**ADC Planning Consultation
Conservation/Design Officer Response**

Application Number	AB/2/18/HH
Address	22 Park Place Arundel BN18 9BE
Description	Replacement of 9 No. casement windows with new casements & sliding sashes & insertion of a new door opening to the east elevation (resubmission following AB/158/14/HH). This application affects the character & appearance of the Arundel Conservation Area.
Case Officer	Mr R Leal
Date	7.2.18

WEST ELEVATION

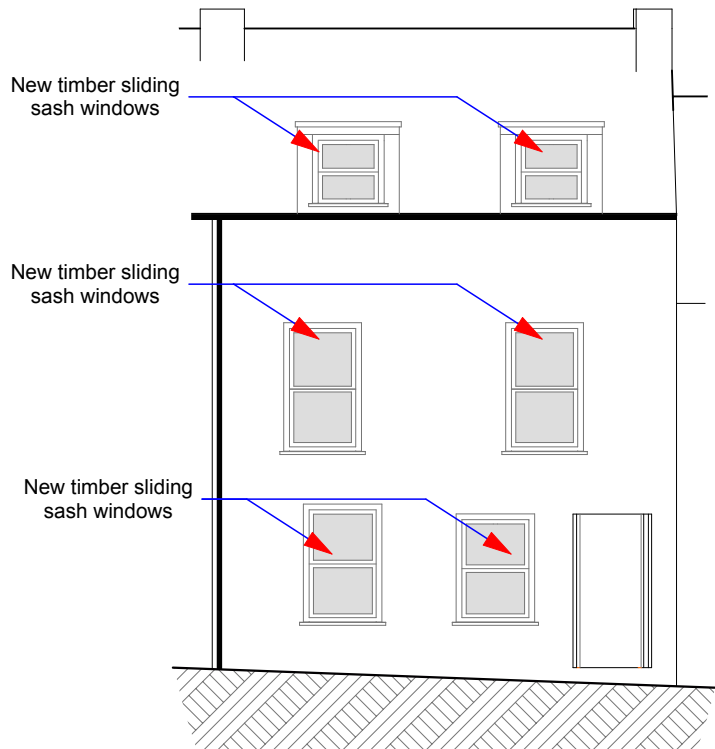
If the application is approved the style and manner of glazing should be reserved by condition. To West Elevation, the sashes should be in the same plane as existing, white painted softwood and single glazed, vertical sliding sashes. It is suggested that windows from another property in the range be copied (rails, glazing bars, horns etc), to ensure visual harmony.

EAST ELEVATION

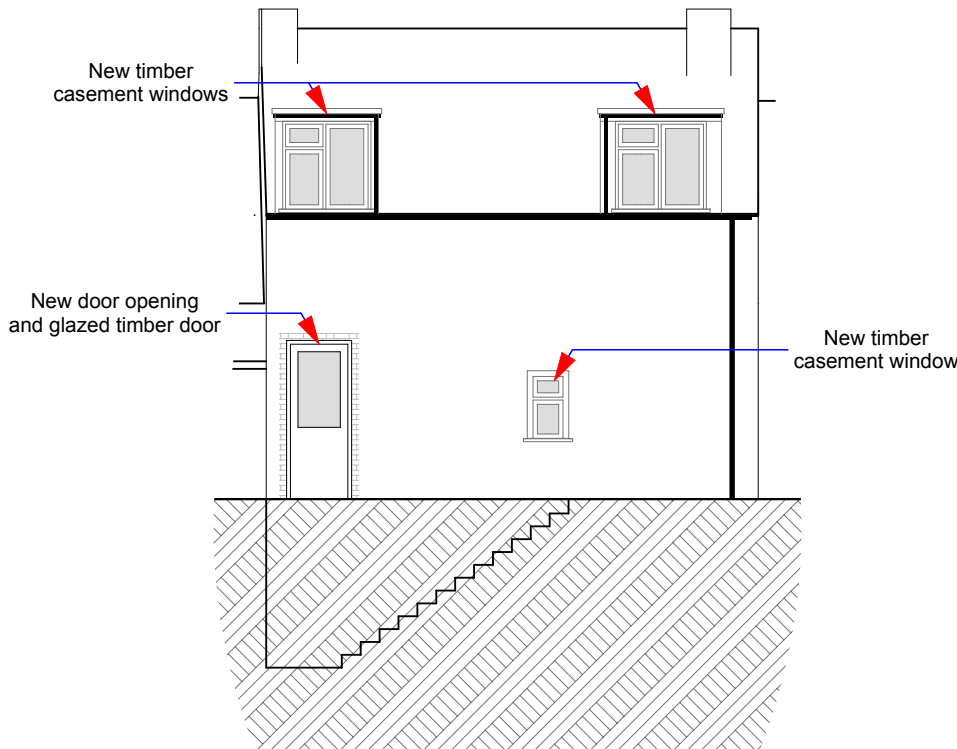
Timber casements to East Elevation should be replicated as existing in white painted hardwood, single glazed. The door style should also be reserved by condition, as there is insufficient detail at a scale of 1:100 to provide comment, although the insertion of a door at this point is supported.
